CITY OF PORTLAND, MAINE

January 7, 2014

Project Name: Residential townhouse - 6 unit condominium
Project ID: 2013-187
Project Address: 133 York Street
CBL: 44-1-29 &31
Applicant: 133 York, LLC, Applicant
Planner: Jean Fraser

SUBDIVISION RECORDING PLAT

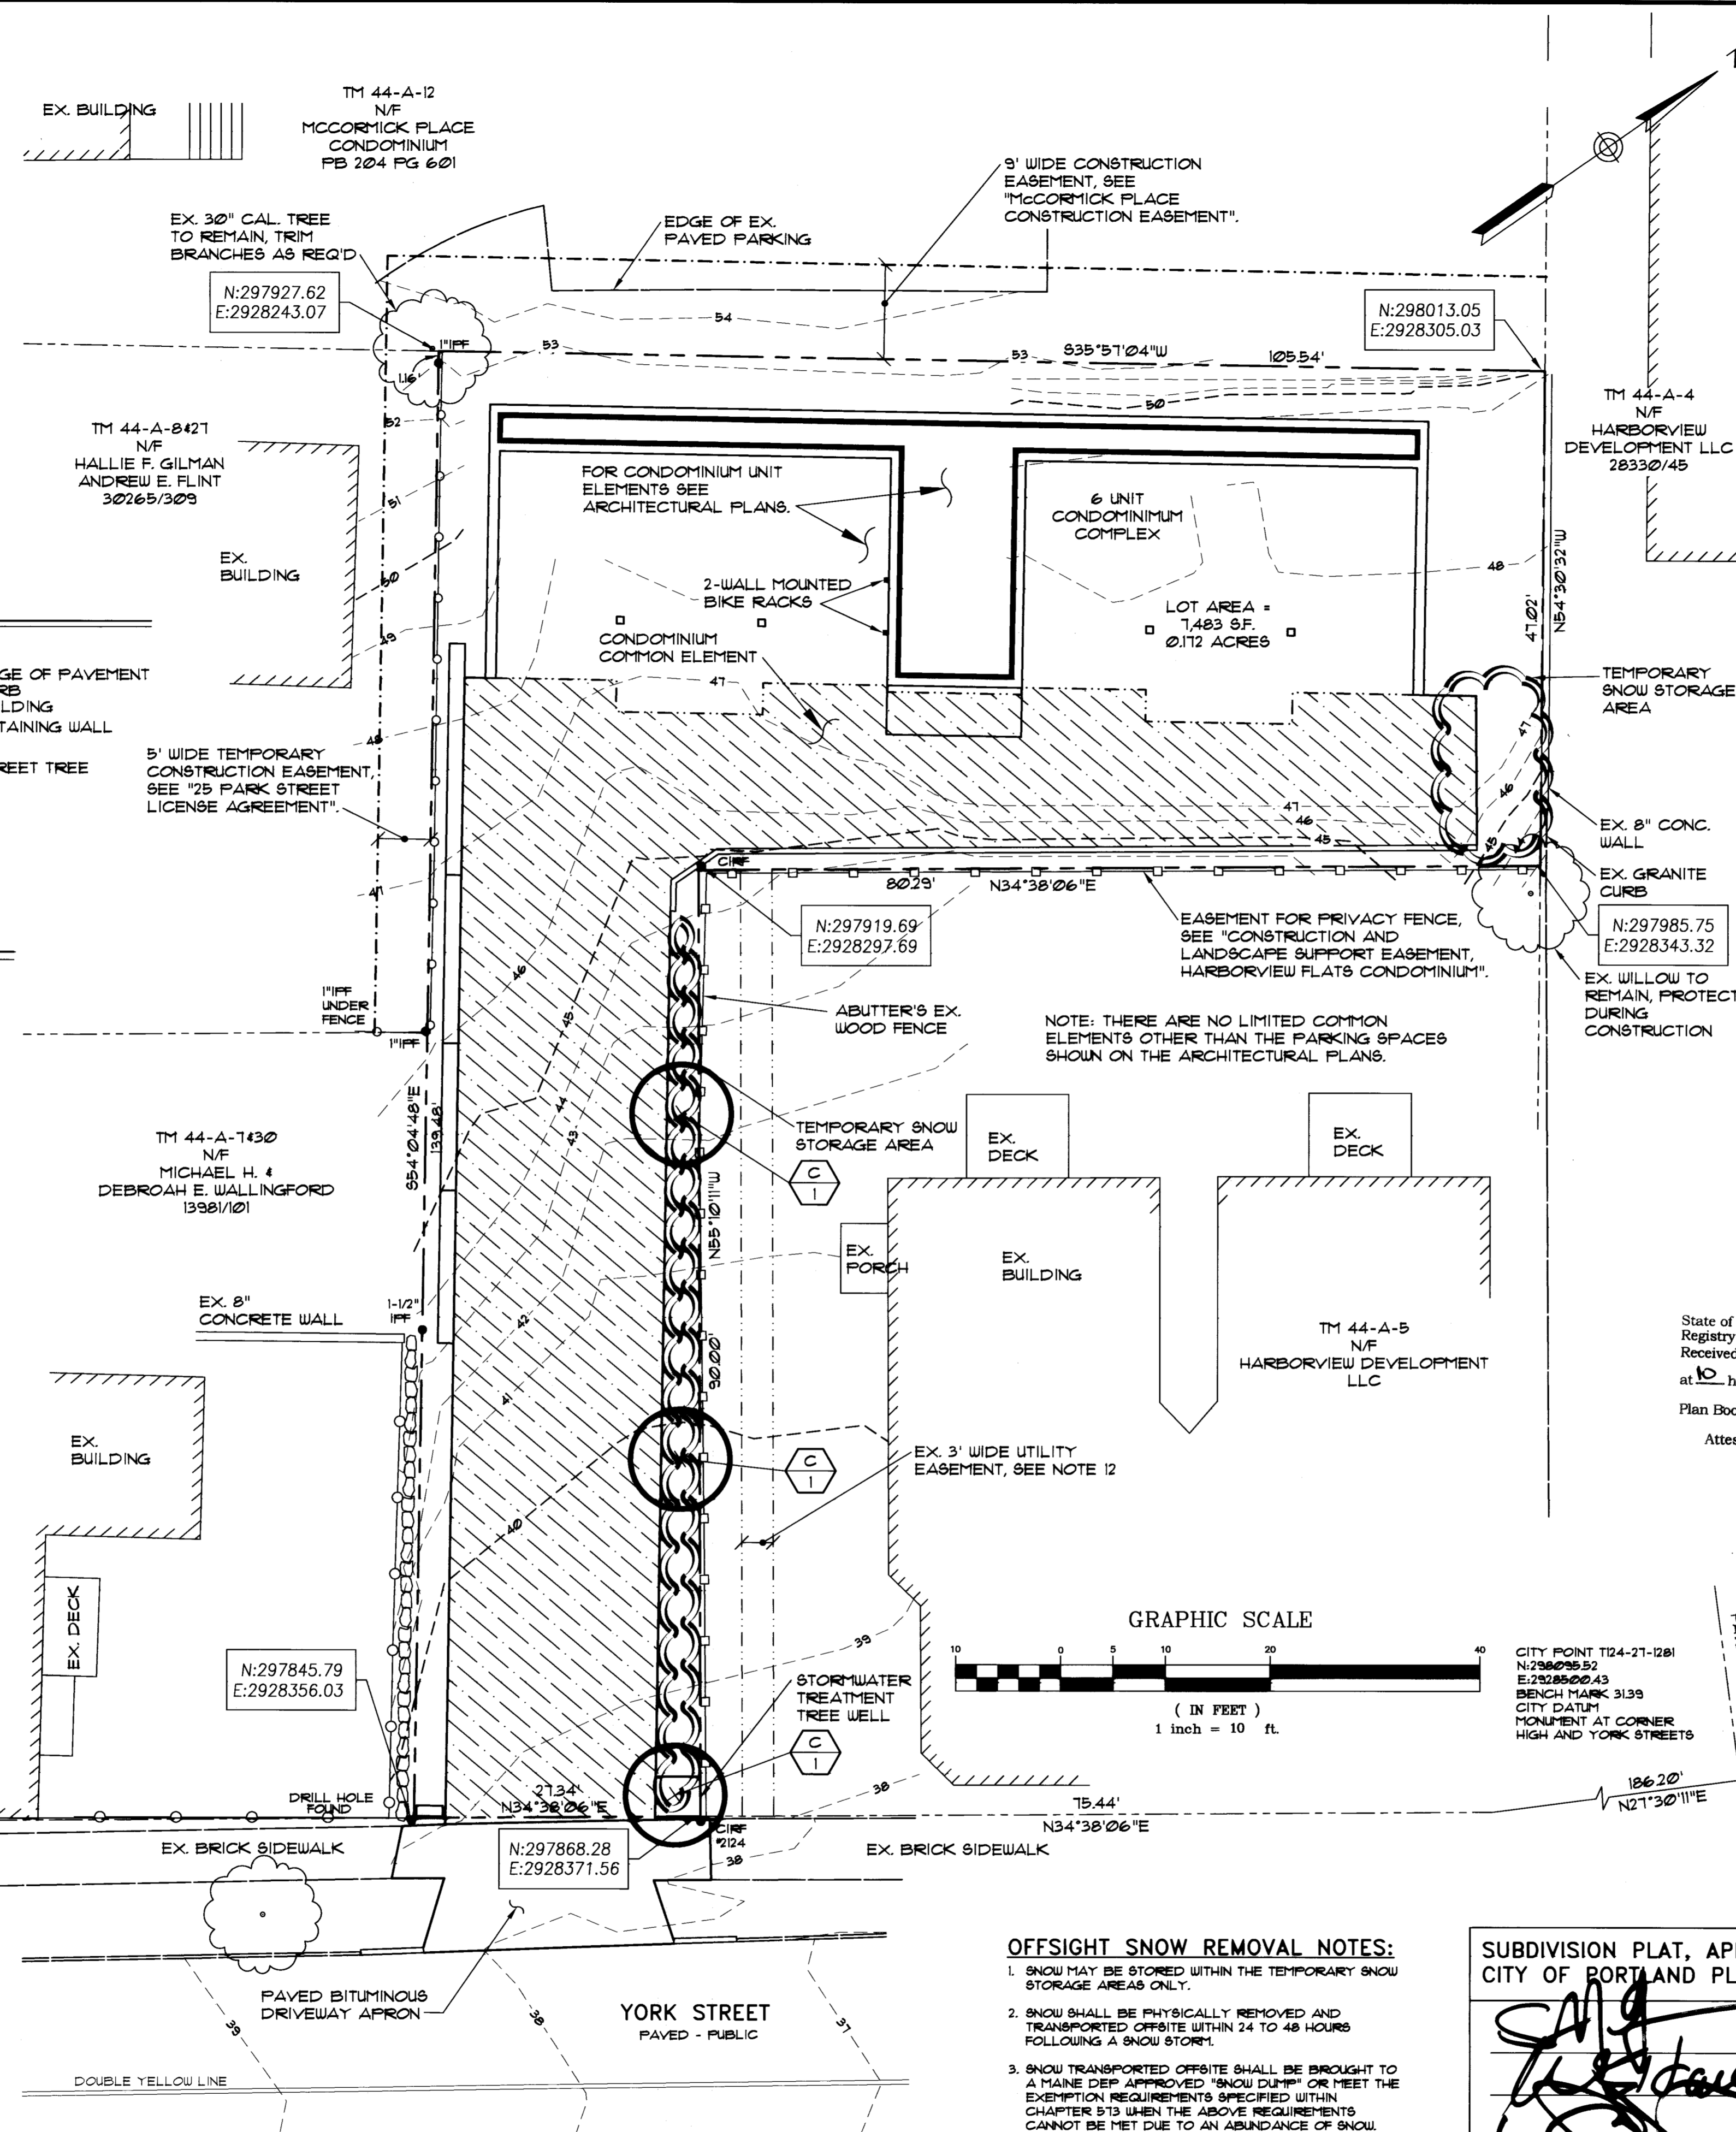
- i. That the Subdivision Plat shall be finalized to the satisfaction of the Planning Authority, Corporation Counsel, and Department of Public Services and include detailed references to easements, snow removal, tree preservation, stormwater system maintenance, relevant conditions, and addressing the comments of the Associate Corporation Counsel dated 1.23.2014; and

** in docs to be submitted re ii above*
- v. That the Subdivision Plat shall include a note confirming the Snow Removal Plan details and that the Condominium Association is responsible for this being undertaken in a timely fashion.
done
